Subject: Homestead at Sterling Ranch Filing No. 2 Final Plat, Review #3 (SF-19-004)

The Park Operations Division of the Community Services Department has reviewed the Homestead at Sterling Ranch Filing No. 2 Final Plat, Review #3, and has the following additional comments of behalf of El Paso County Parks. County staff has reviewed the Sand Creek Bank Stabilization plans and is concerned that these necessary creek bank mitigation efforts will negatively affect the dedicated 25-foot trail easement (Record #218054786), and the County's ability to construct the trail in the future. Staff concerns are as follows:

CHANNEL STABILIZATION STA: 98+00 TO 103+00
SCALE: 1" = 30'

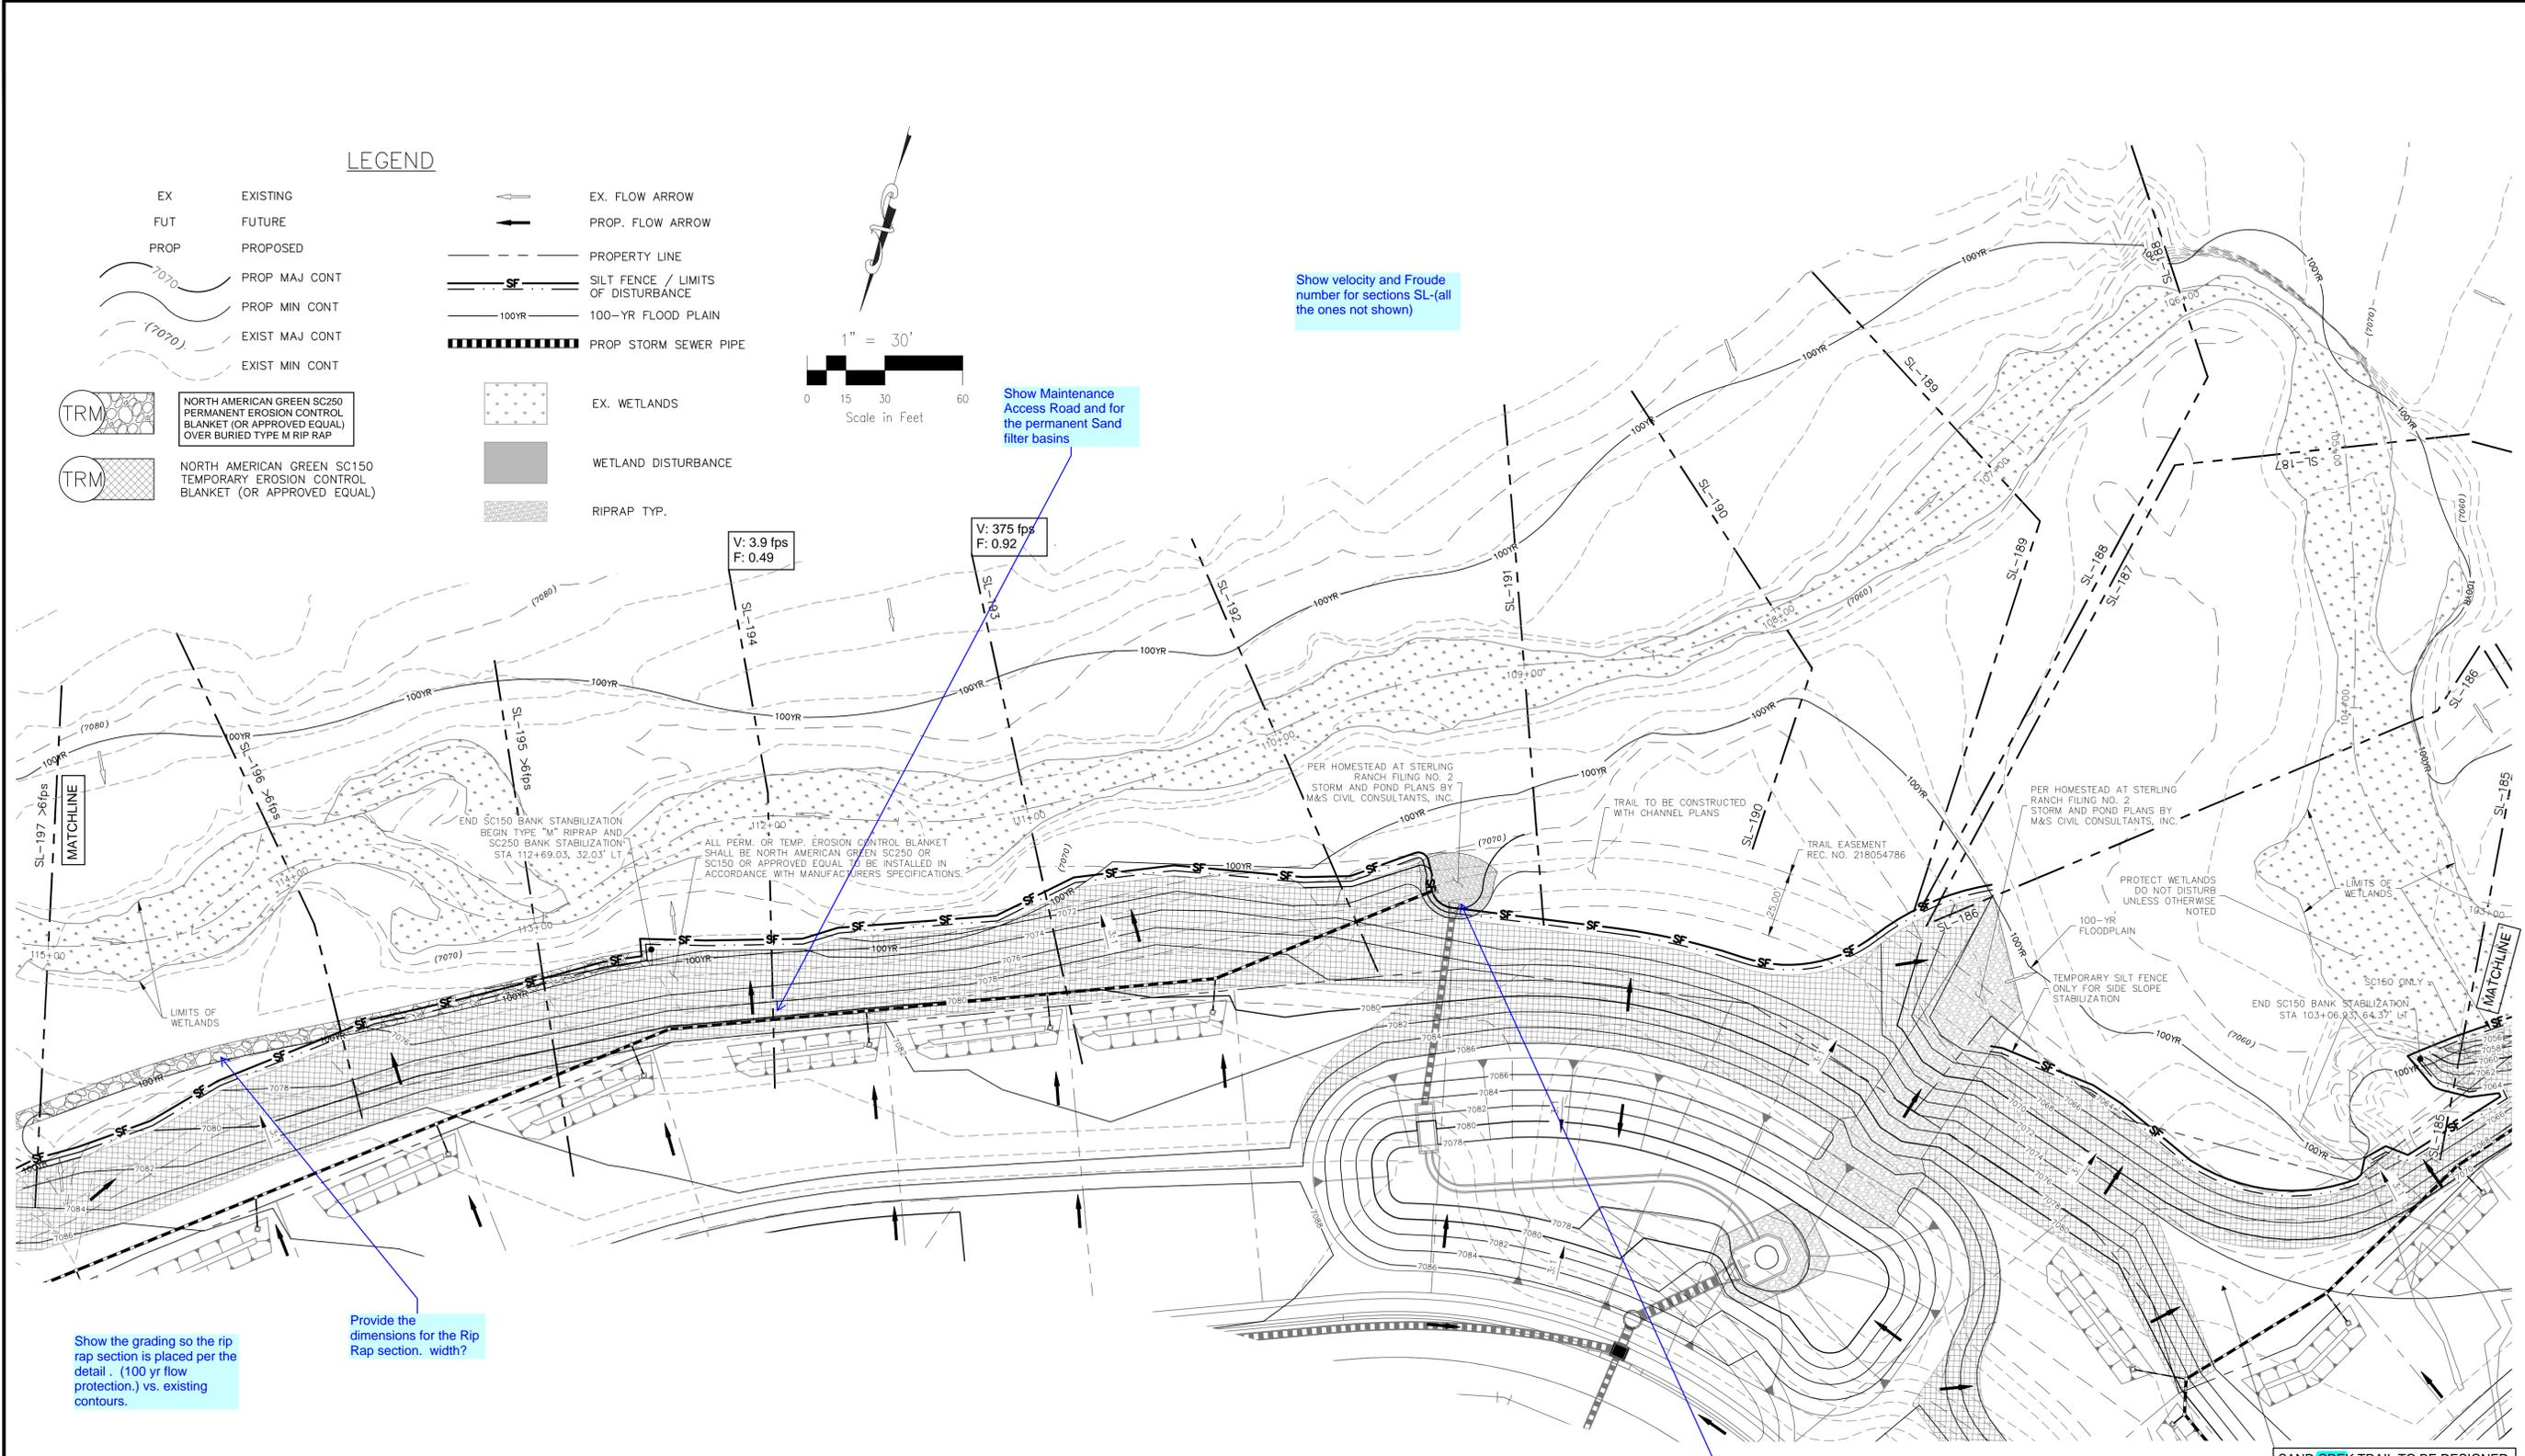
5. Page GR02 of the Stabilization Plans shows a length of crusher fines trail with one section that reflects a 15% longitudinal grade, between Stations 98 and 99. The 15% grade is far too steep for a regional trail, as trails of this type should remain at less than 10% average. Furthermore, is the developer going to construct this length of trail, or is the crusher fine trail being shown for general reference?

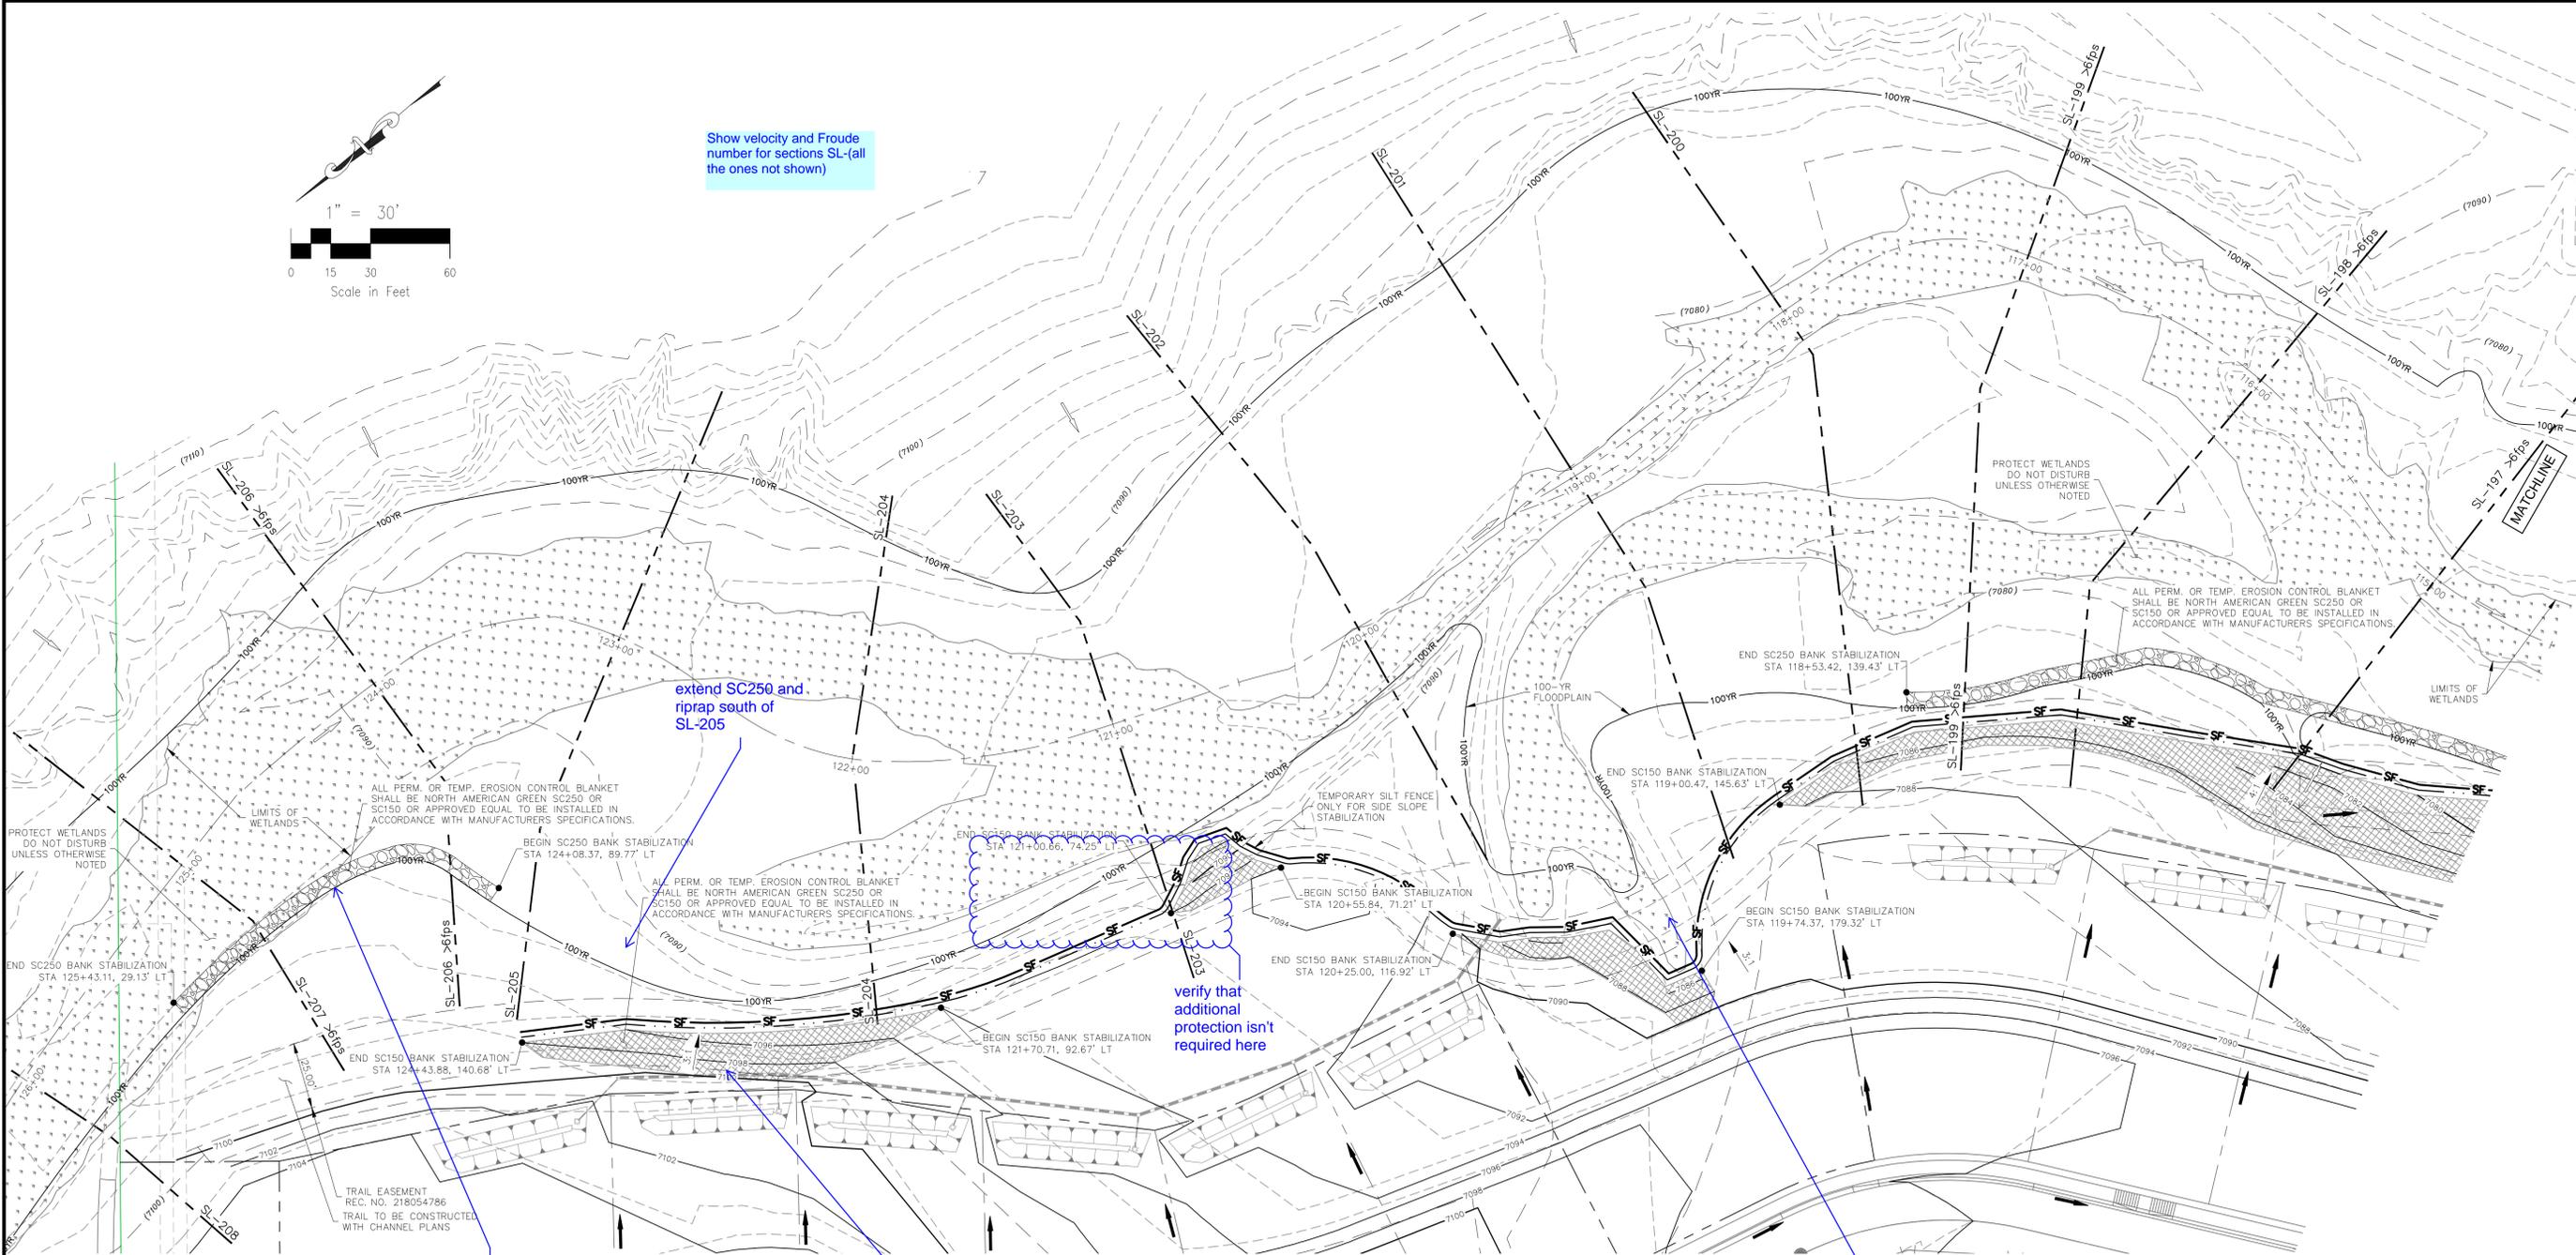
2. The Stabilization Plans also show a riprap outlet works located in the middle of the trail easement, between Stations 109 and 110. The trail would not be able to span this obstacle, so it is requested that the outlet works be located outside of the trail easement.
